Local Policing Branch

Your Ref: WA/44/17/OUT

Re: Land at Stakers Farm, North End Road, Yapton.

Thank you for your correspondence of 10th July 2017, advising me of an outline planning application for 70No residential dwellings including 30% affordable, public open space & associated landscaping. All matters to be reserved apart from Access (access to be achieved via permitted road (reference Y/93/14/OUT)). This application is a Departure from the Development plan, at the above location, for which you seek advice from a crime prevention viewpoint.

PROPOSED SITE PLAN

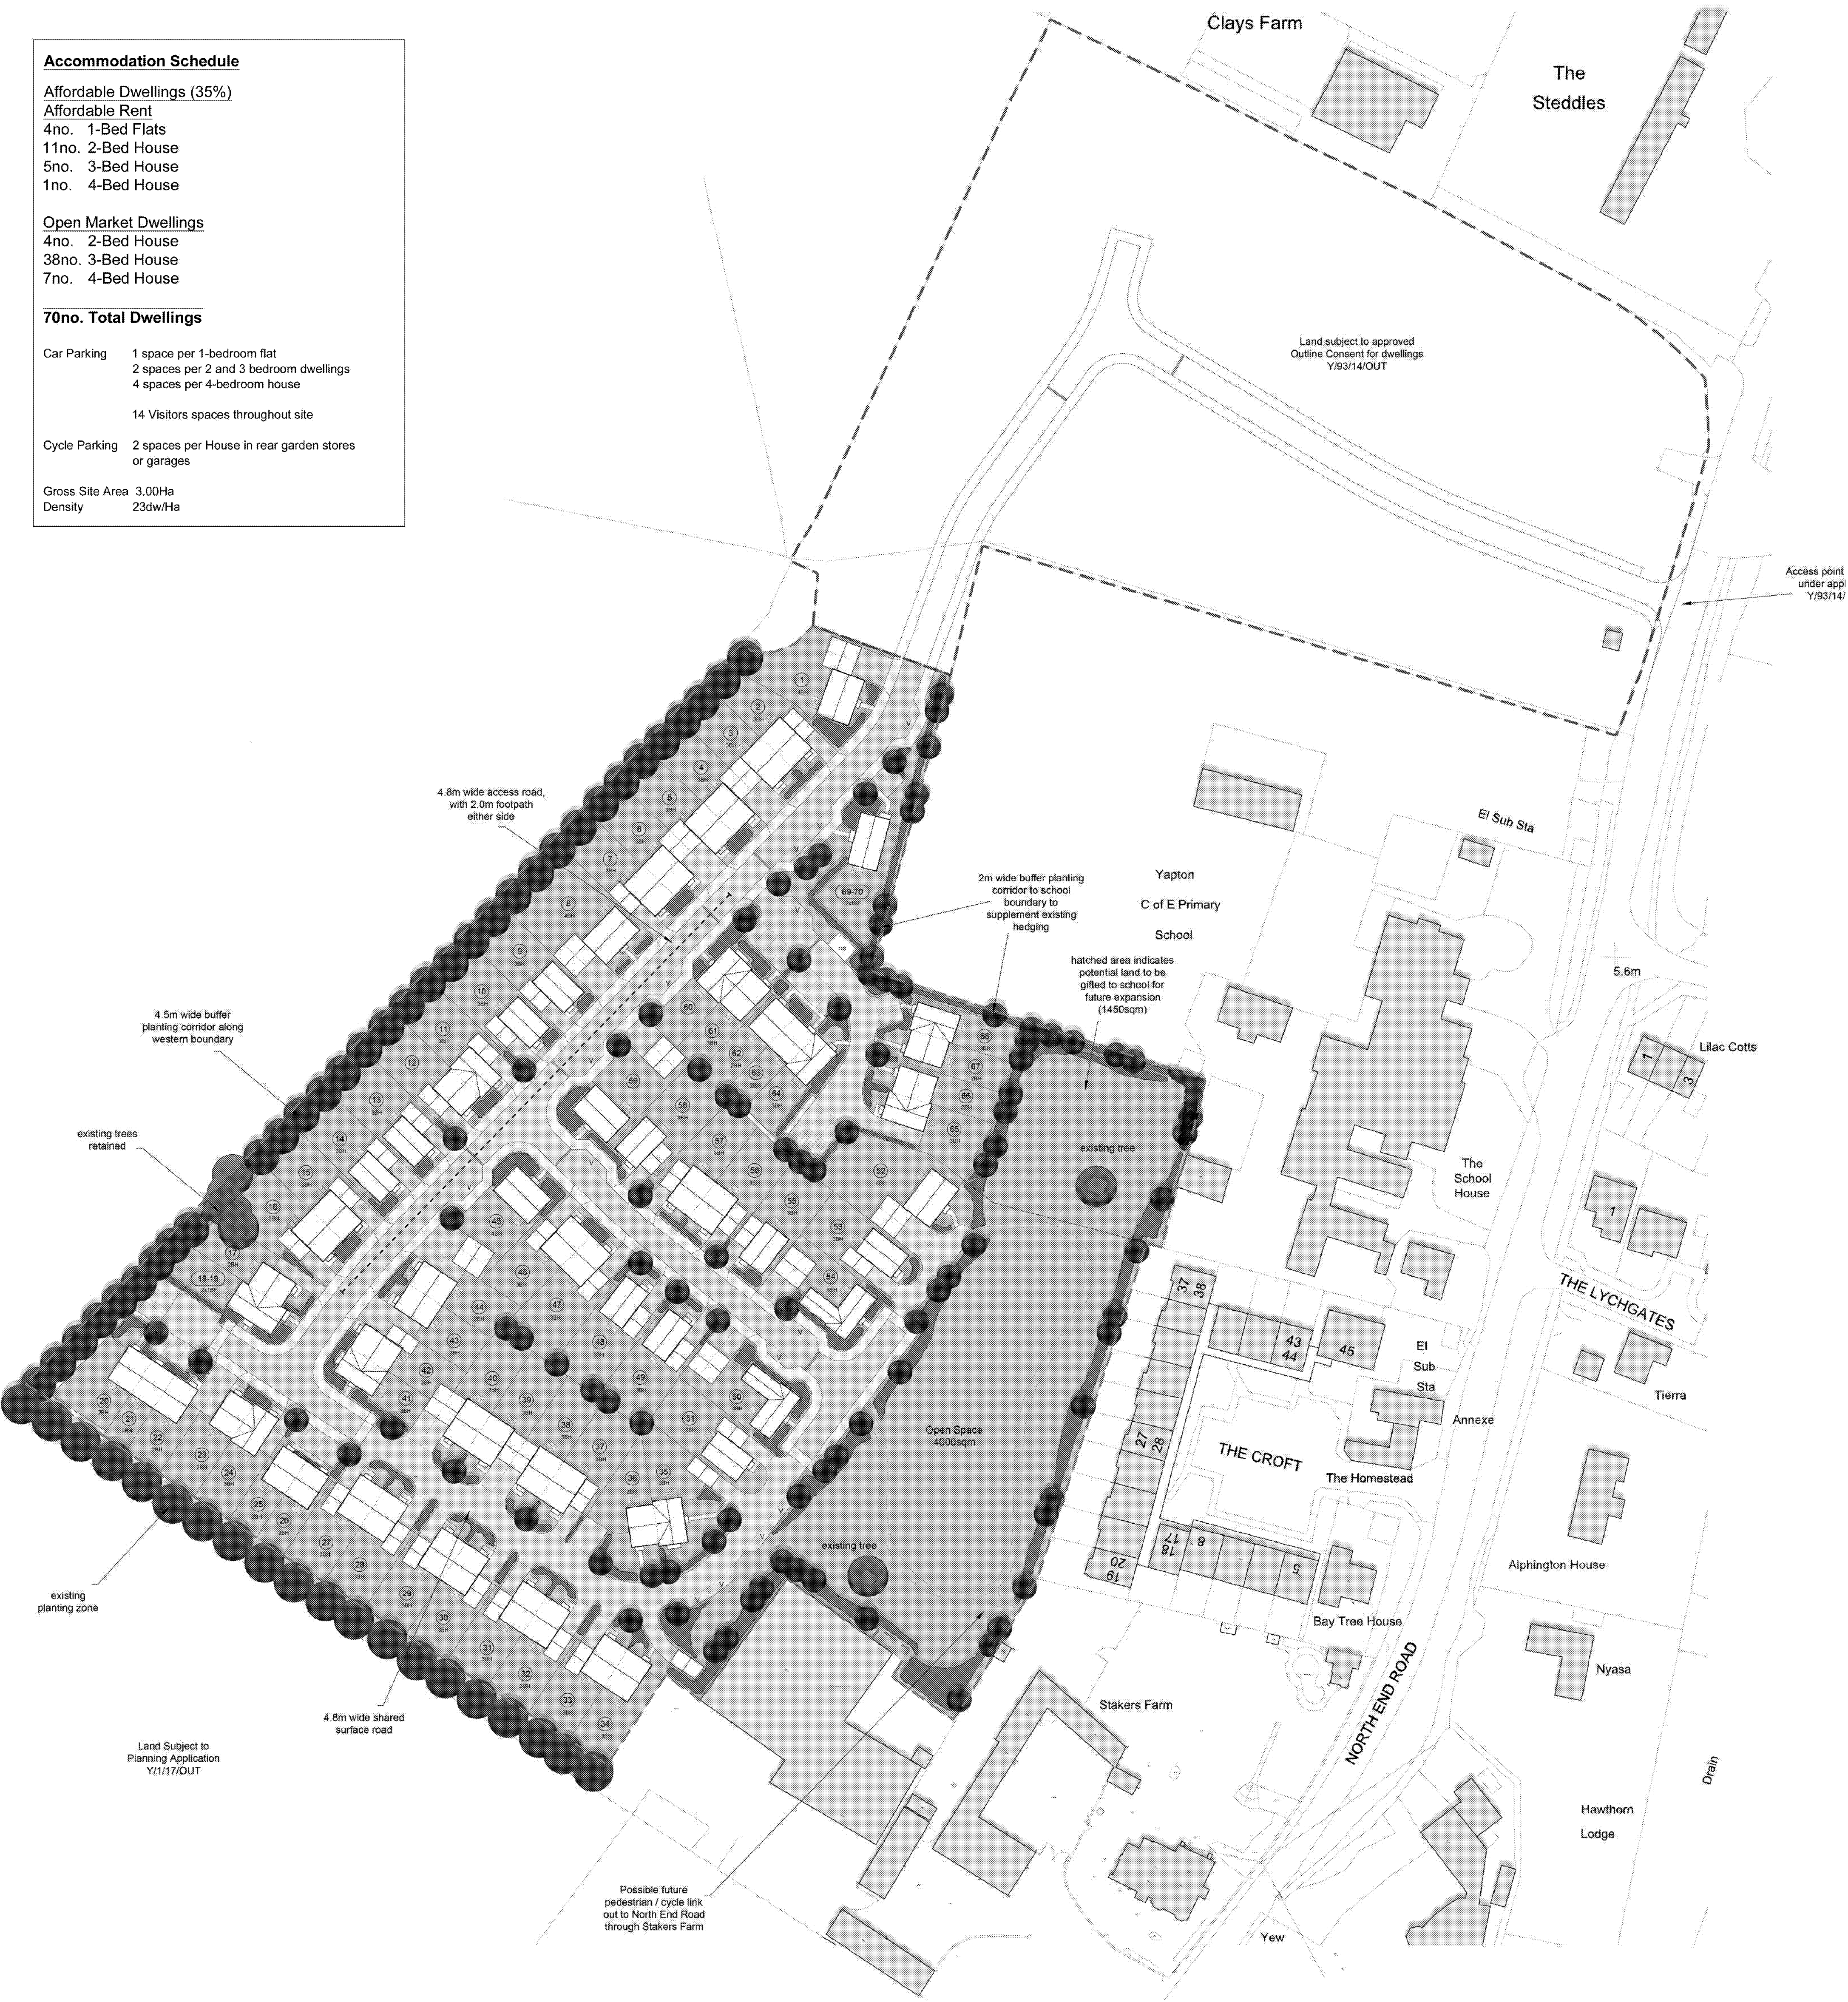
The design and layout whilst very positive has created an unobserved parking area behind plot 52 that is vulnerable, additionally this area provides unobserved access to a number of rear gardens.
